**KIRKLEES METROPOLITAN COUNCIL
INVESTMENT & REGENERATION SERVICE**

Reference No:	2024/70/90686/E
Site Address:	230, Roberttown Lane, Roberttown, Liversedge, WF15 7LL
Description:	Variation condition 2 (plans) on previous permission 2021/90581 for demolition of existing bungalow and erection of 2 dwellings
Recommending Officer:	Jennifer Booth

DECISION – APPROVE VARIATION OF CONDITION 2

Drawing: As built Elevations

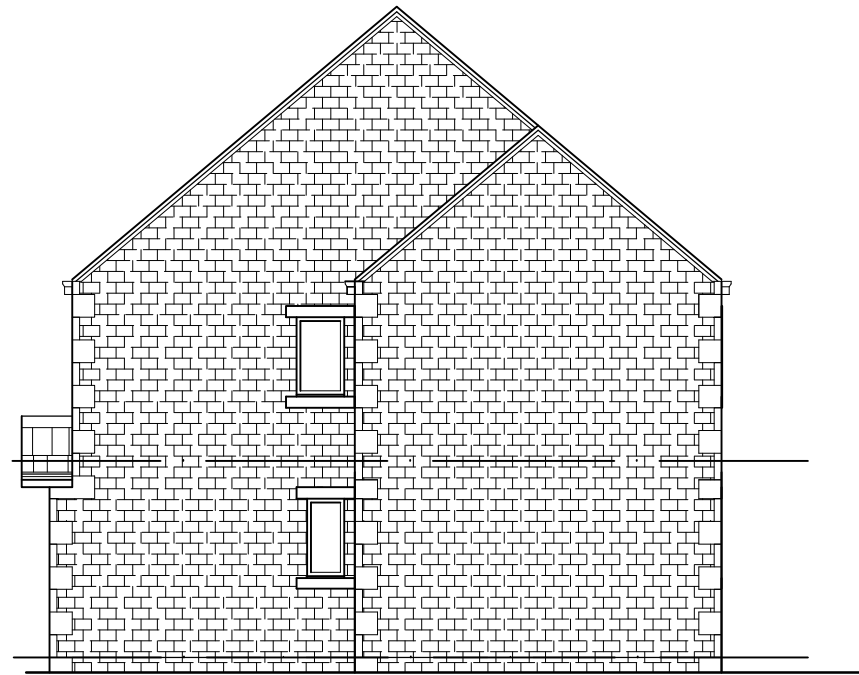
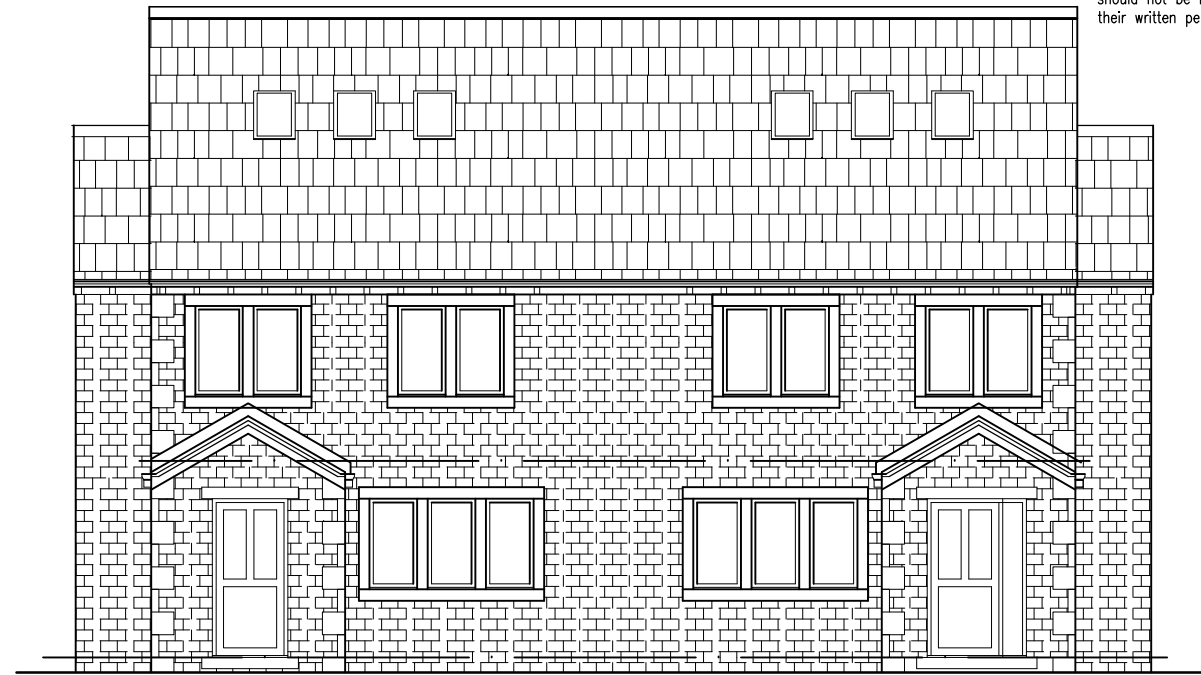
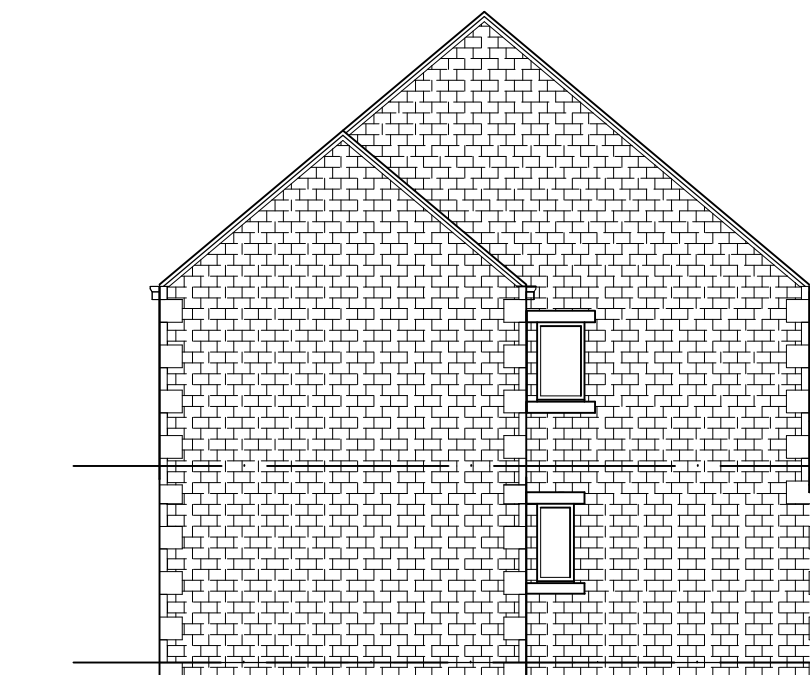
- This Section 73 application seeks to vary the approved plans due to design changes. The proposed alterations are as follows: Provision of accommodation in the loft space
- Insertion of roof lights to the front roof plane
- Installation of solar panels on the rear roof plane
- The previously approved single storey side projections would also be extended upwards to two storey level.

The external alterations to the appearance of the approved dwellings are limited to the roof lights, solar panels and side projections. Given the mix of

property types in the vicinity together with the limited scope of the alterations, the alteration to the appearance is considered to be acceptable in terms of visual amenity.

The impact of the development as a whole on the amenity of neighbouring occupants has been assessed as part of the original permission. The use of roof lights would not provide additional opportunities for overlooking and the solar panels would not have any impact on the neighbouring properties. The increase in height of the side projections is not considered to be of detriment to residential amenity due to their limited width and confines within the site.

Client:	John Brooke Builders	
Project:	230 Roberttown Lane Liversedge WF15 7LL	
Drawing:	As built Layouts	
Date:	Feb 2024	Scale: 100 @ A3
Drawing No:	2067/312	Rev:

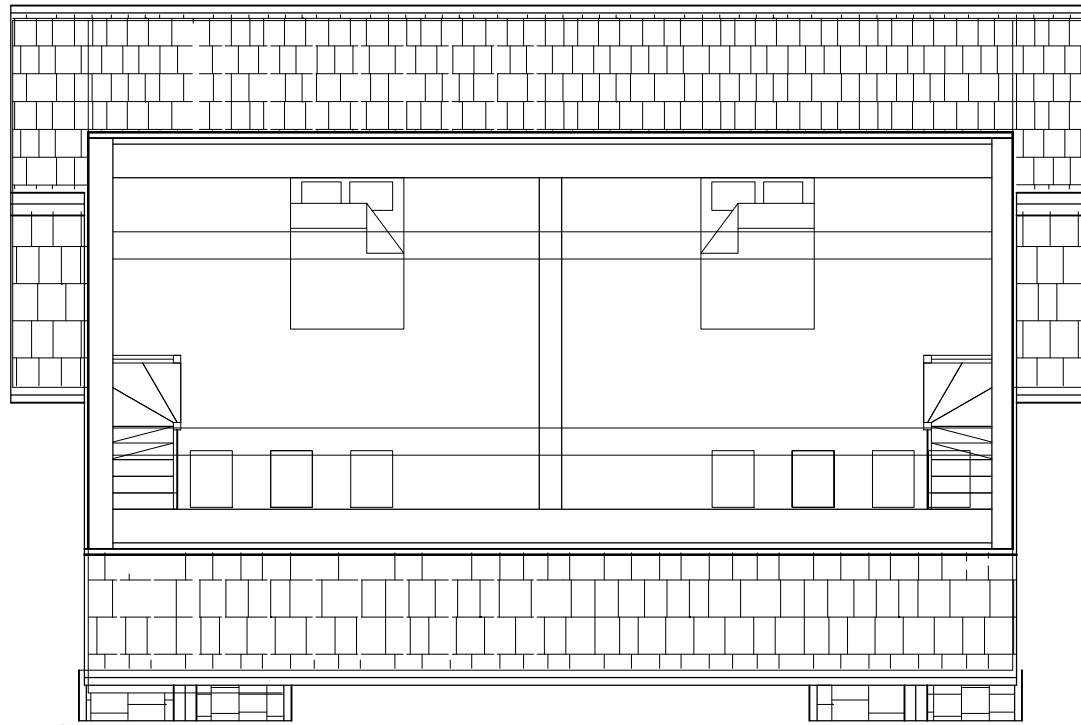
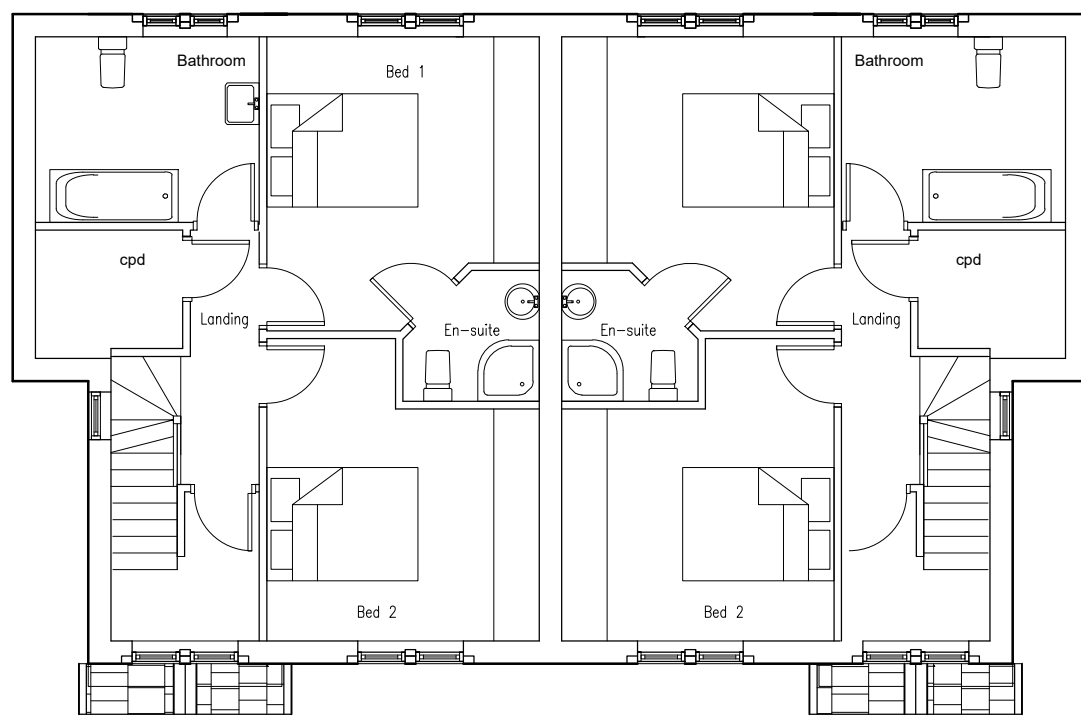
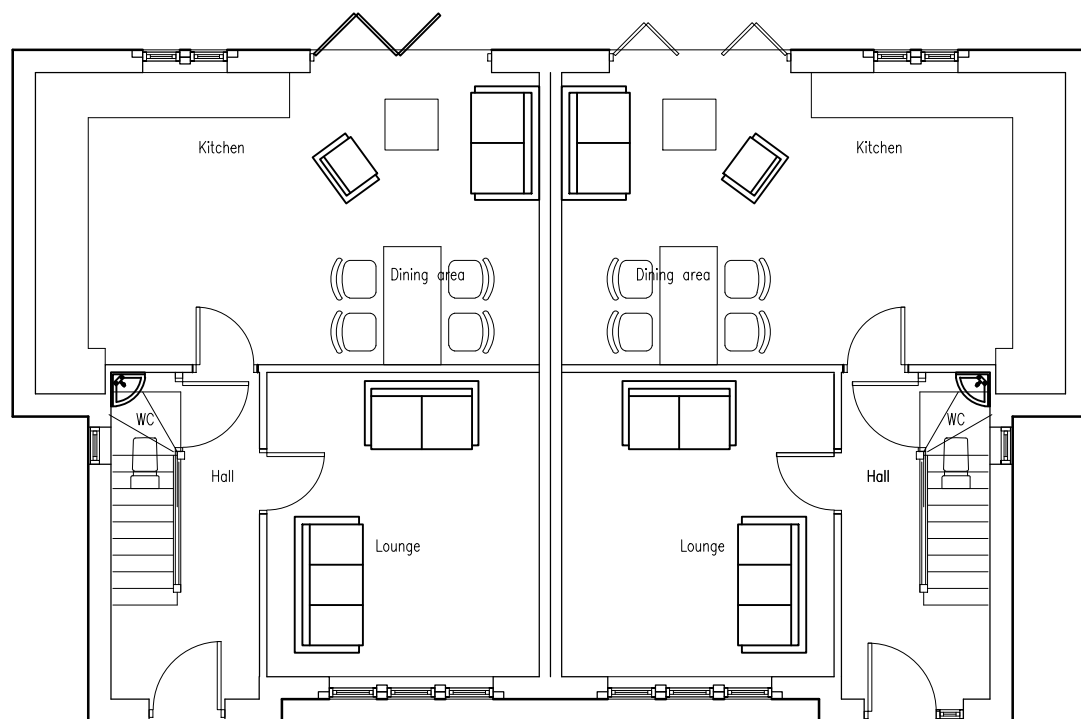
The proposals will reconfigure the accommodation to retain 3 bedrooms and as such would not result in any intensification of the domestic use. The approved parking arrangements are therefore considered to represent a sufficient provision. As such the scheme would not represent any additional harm in terms of highway safety and as such complies with Policy LP22 of the Kirklees Local Plan.
